Tech Note

To:	Fiona Fitzgerald	From:	Will Fairman
Company:	Arun District Council	Pages:	2
CC:	Kevin Wawman Alastair Dineen Ellie White Simon Davis	Date:	15 th February 2019
Project:	AS10285 Land to the West of Orchard Business Park, Yapton	Ref:	AS10285.180326.ADS
Subject:	Response to Objection from Arun District Council's Environmental Health Department

Figure AS10285/TH1

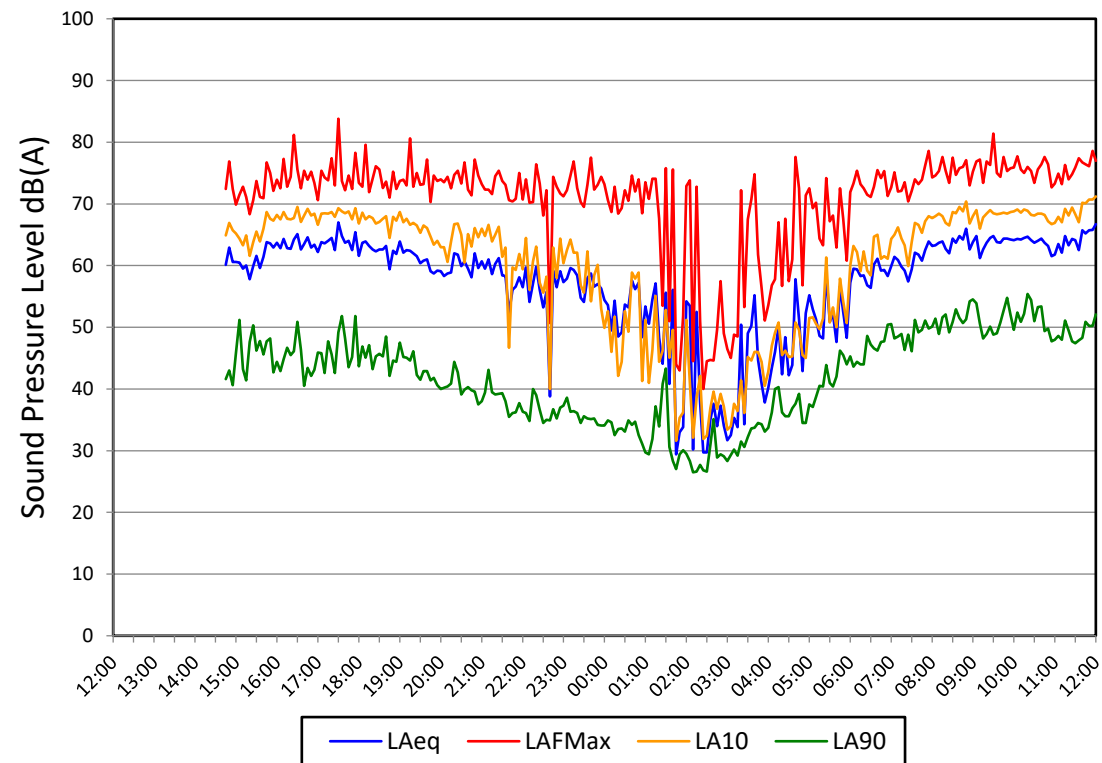
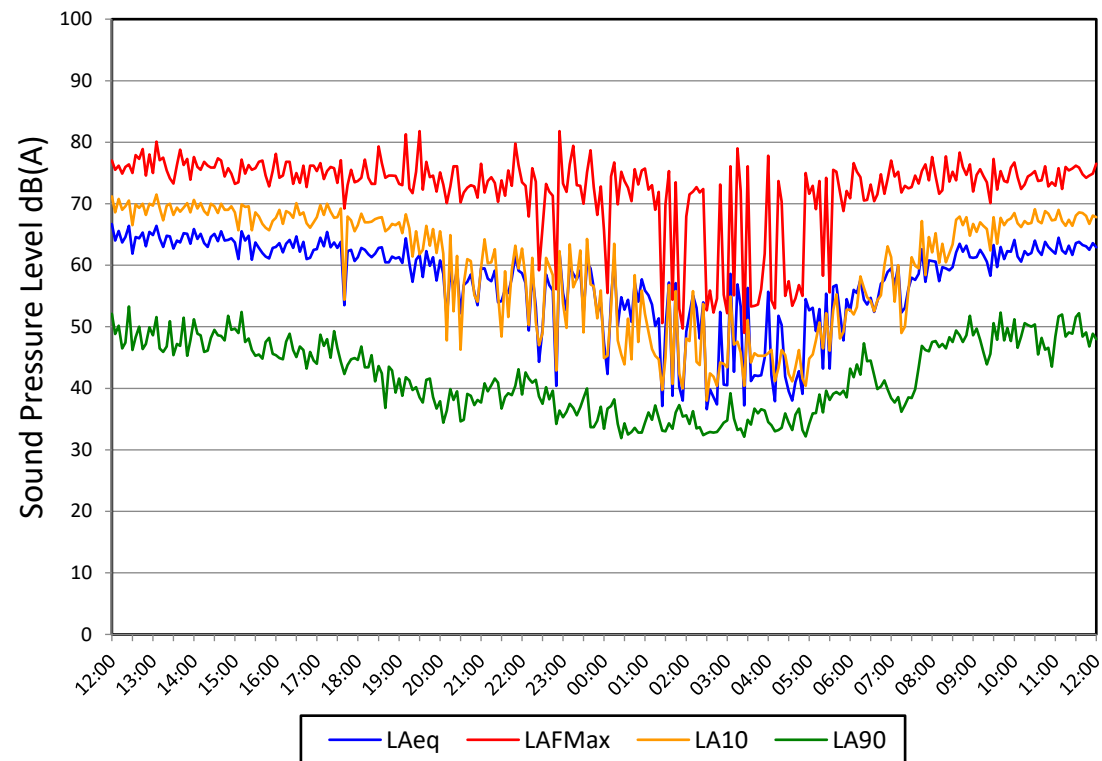
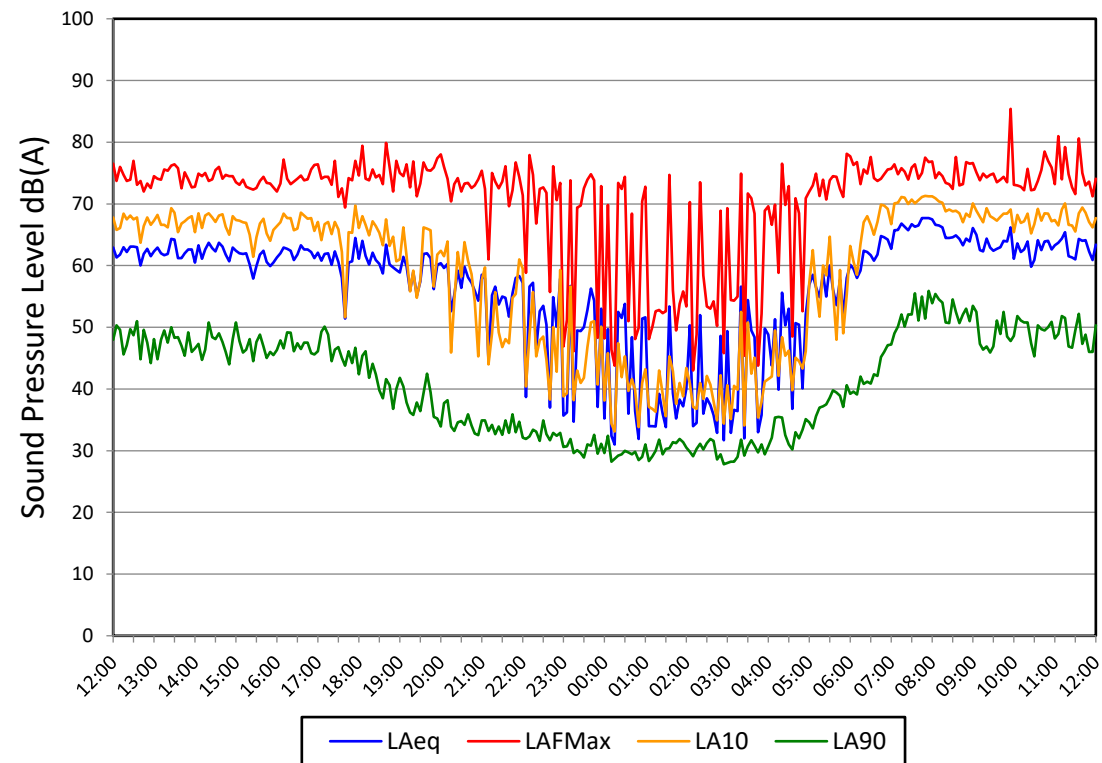
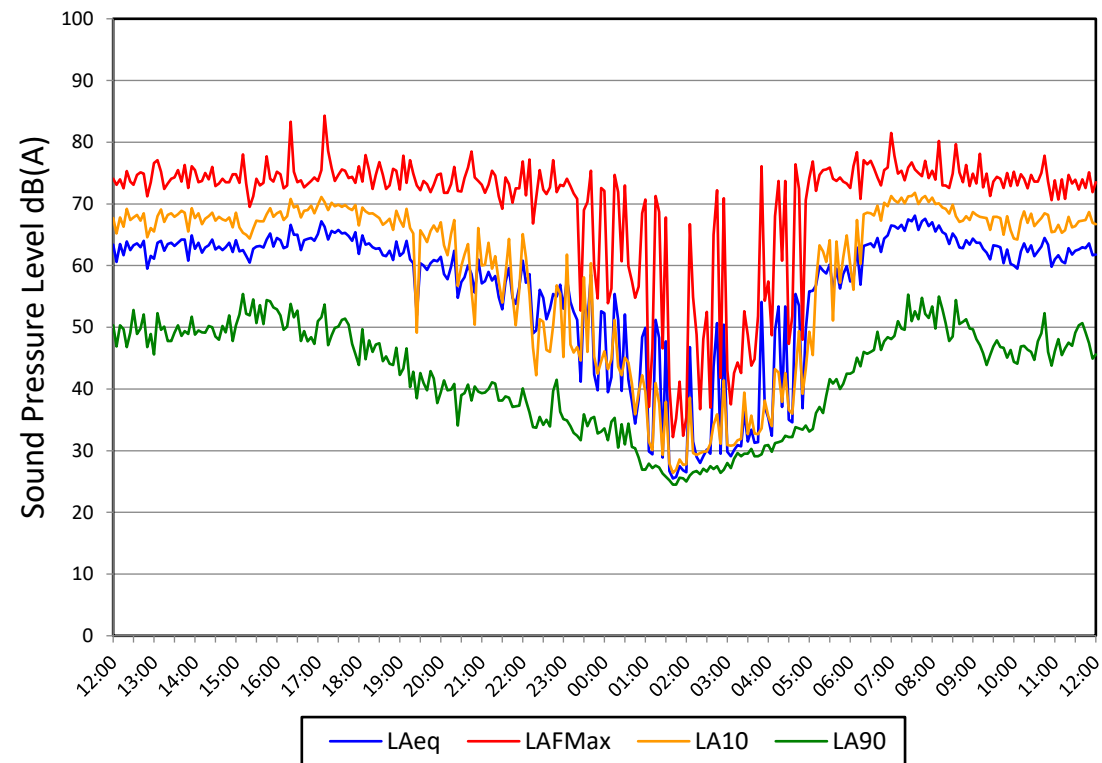
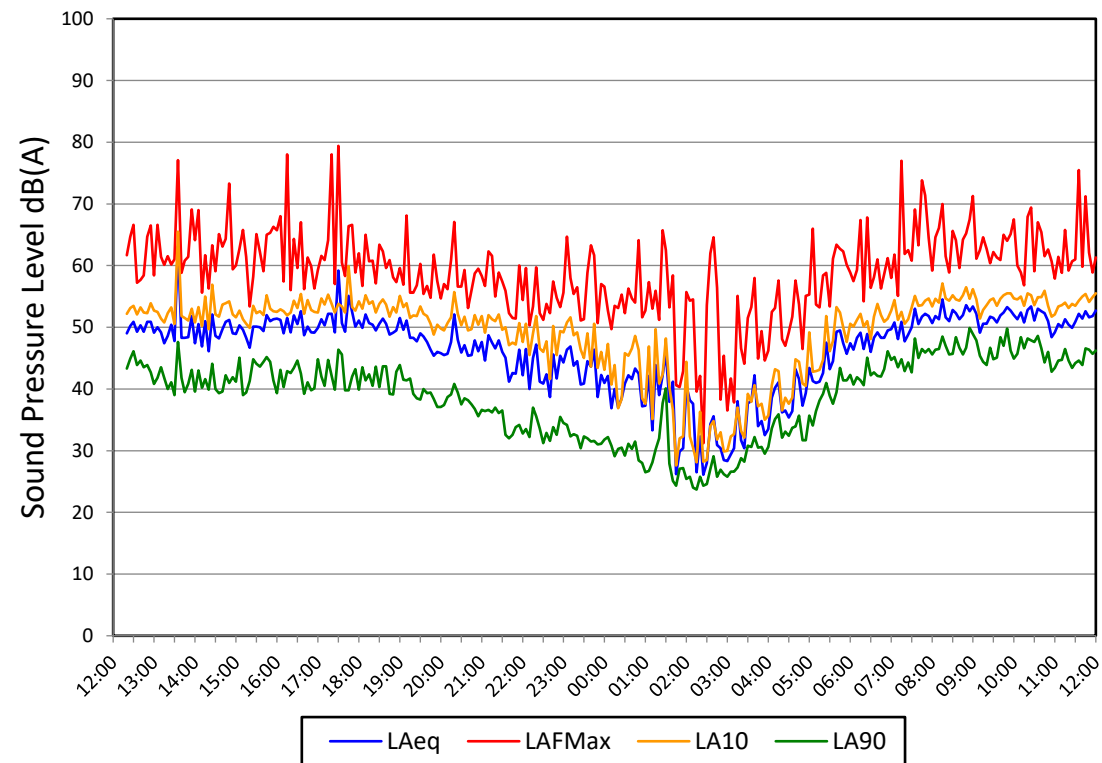
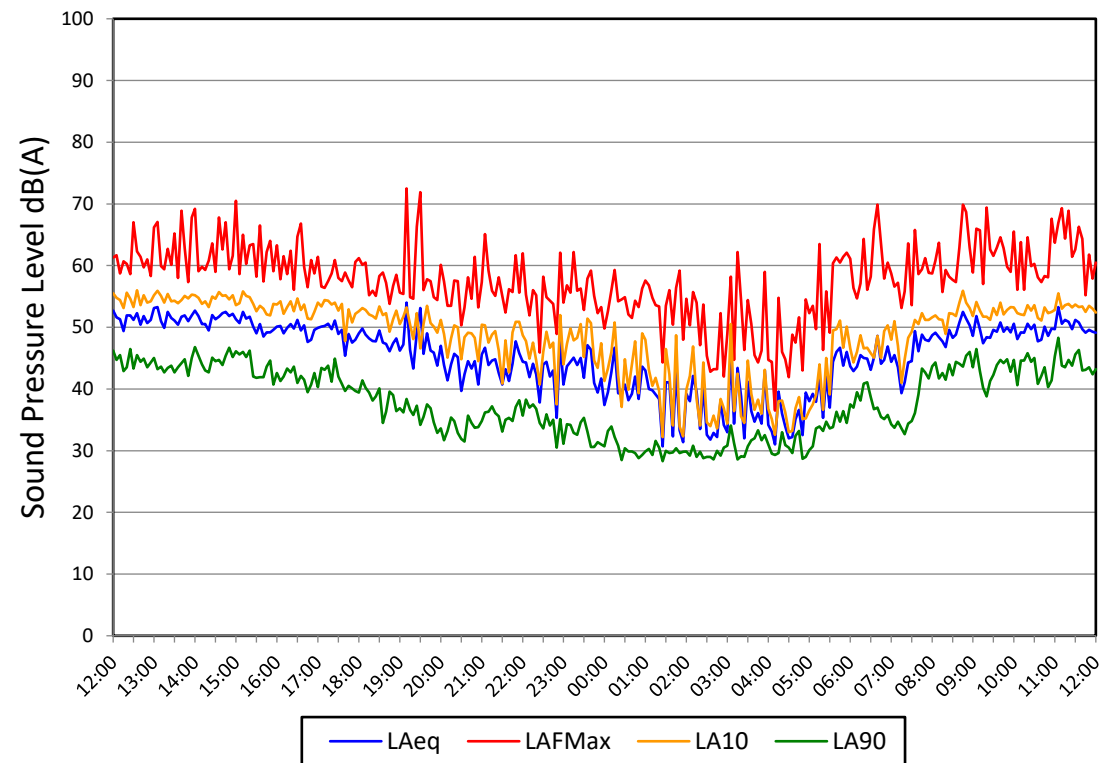
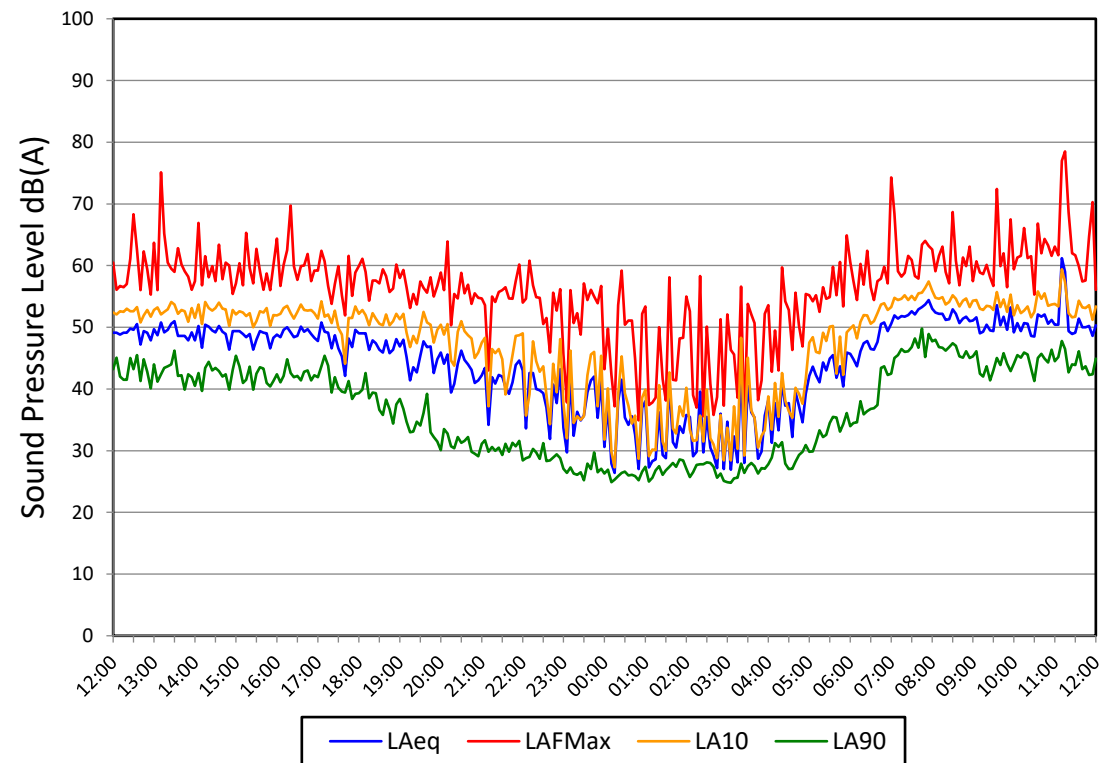
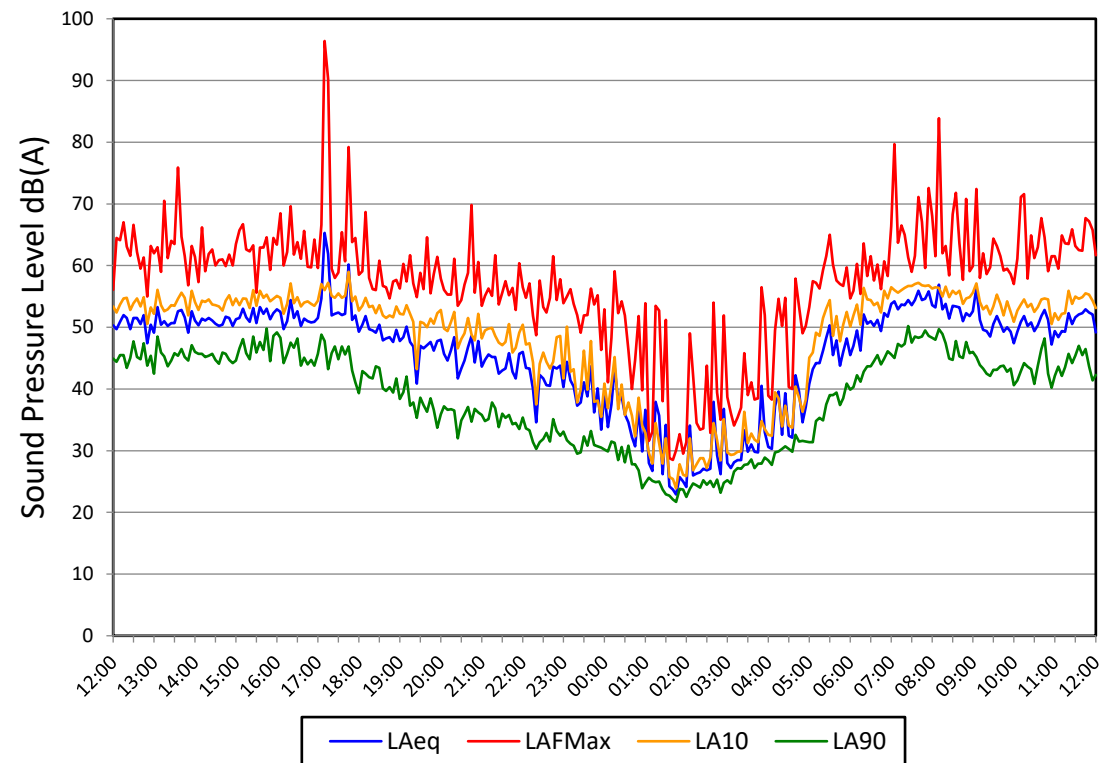
5. After reviewing the raw data it needs to be considered that this location has very high noise levels throughout the day, evening and into the early hours (2/3am) and no indication of the reasons for this has been provided. The proposals to mitigate this are to ensure that windows are sealed shut and alternative ventilation is installed. I believe this will not provide sustainable well-built residential properties for future residents.

6. The noise levels in the raw data appear very high for this area, especially through the night, no explanation or justification for this was given in the report. My awareness of the noise environment for this site conflicts with the raw data given (for example L_{Aeq} of low 50's at 1 or 2am shown in the raw data).

Whilst on the phone we compared some of the worst case $L_{Aeq,5min}$ measurements during the night-time period with the corresponding $L_{A90,5min}$ measurements during the same 5-minute period. For example, The $L_{Aeq,5min}$ at measurement position 1 at 03:50 on Tuesday 20th March 2018 was 54.1dB. However, the measured L_{A90} for this period was just 29.4, which is indicative of the background noise level during that measured period. This shows that the higher $L_{Aeq,5min}$ is likely due to a car pass by within that period. This is indicated by the higher L_{Amax} of 76.1dB during the same 5-minute period.
